From: Patz, Logan W.
To: [Martin](#)
Subject: 5109 Central Cielito Lindo K11-D085 TCL Additional Comment
Date: Monday, December 12, 2016 2:46:00 PM
Importance: High

I was able to look at the resubmission for the Cielito Lindo restaurant.

A1.2

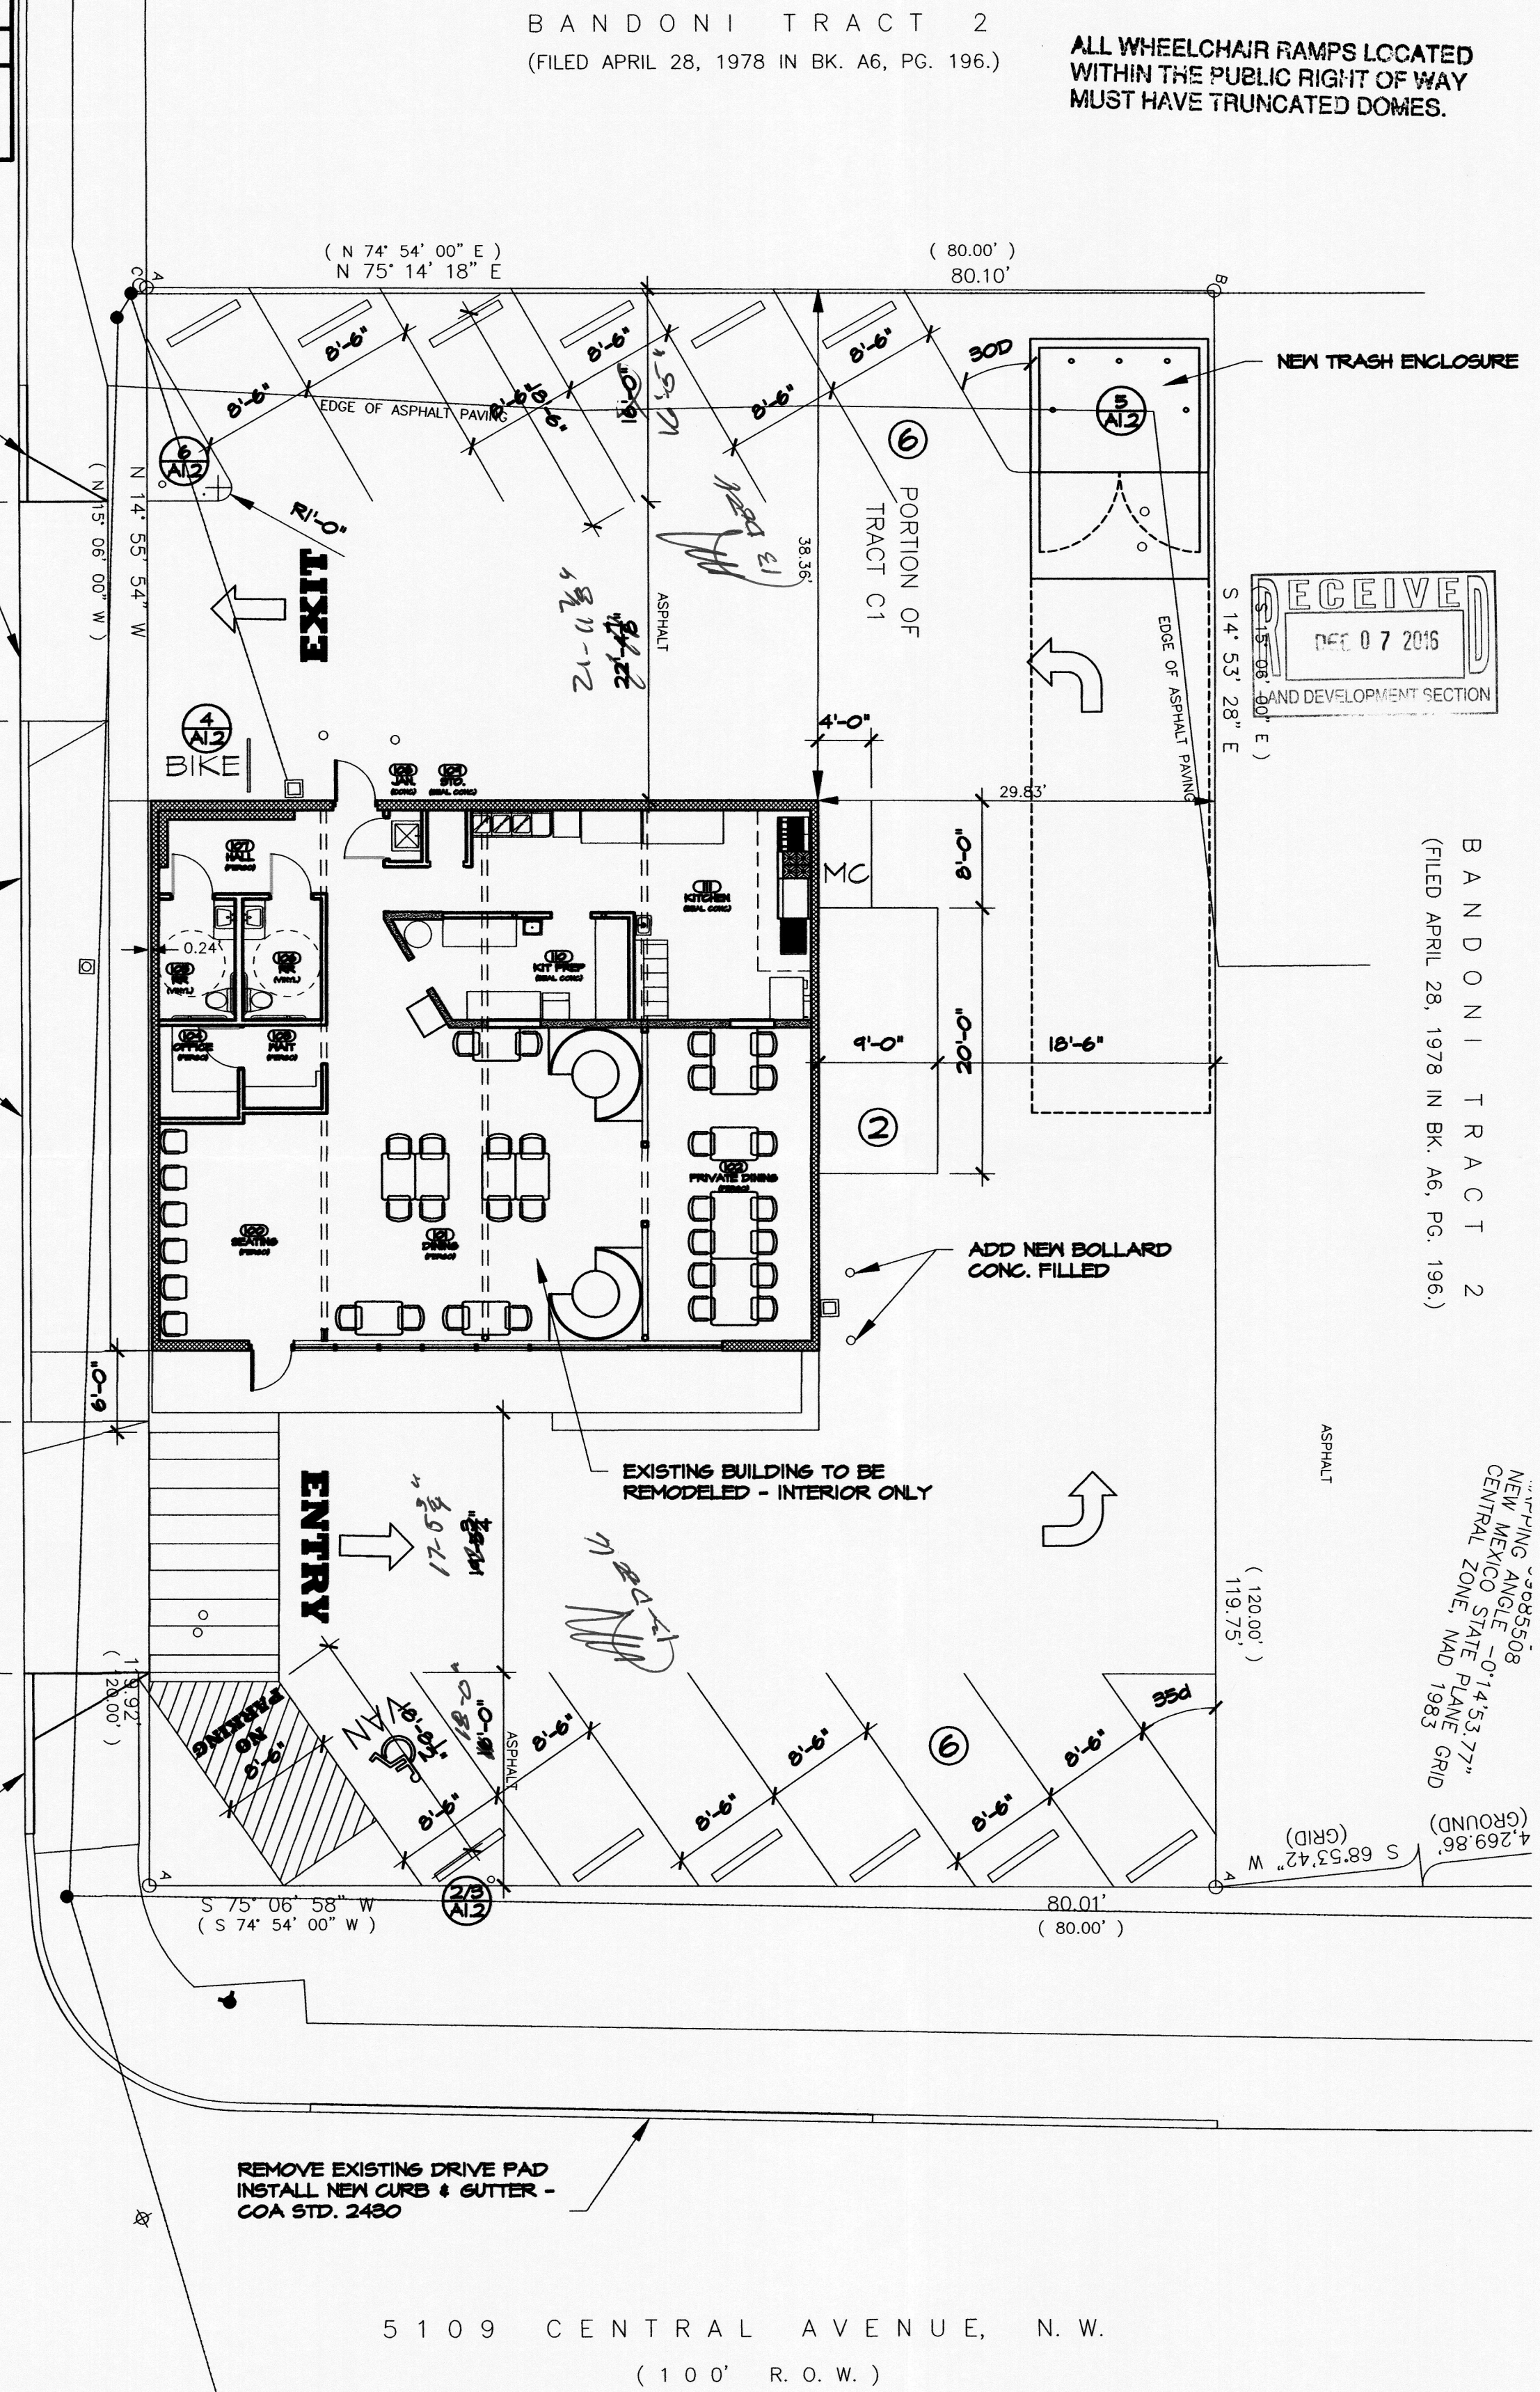
The parking stalls are still short in length. The you may want to consider extending aisle and reduce the entrance.

The 35 degree angle parking should be about 17' 4" per DPM Figure 23.7.1.

The 30 degree angle should be 16' 5". This is all with an 18 foot aisle. You are showing 16' on both.

Please address the comments, you can redline the plans we have here and update the stamp or resubmit with new stamp date. We will be able to turn it around fast.
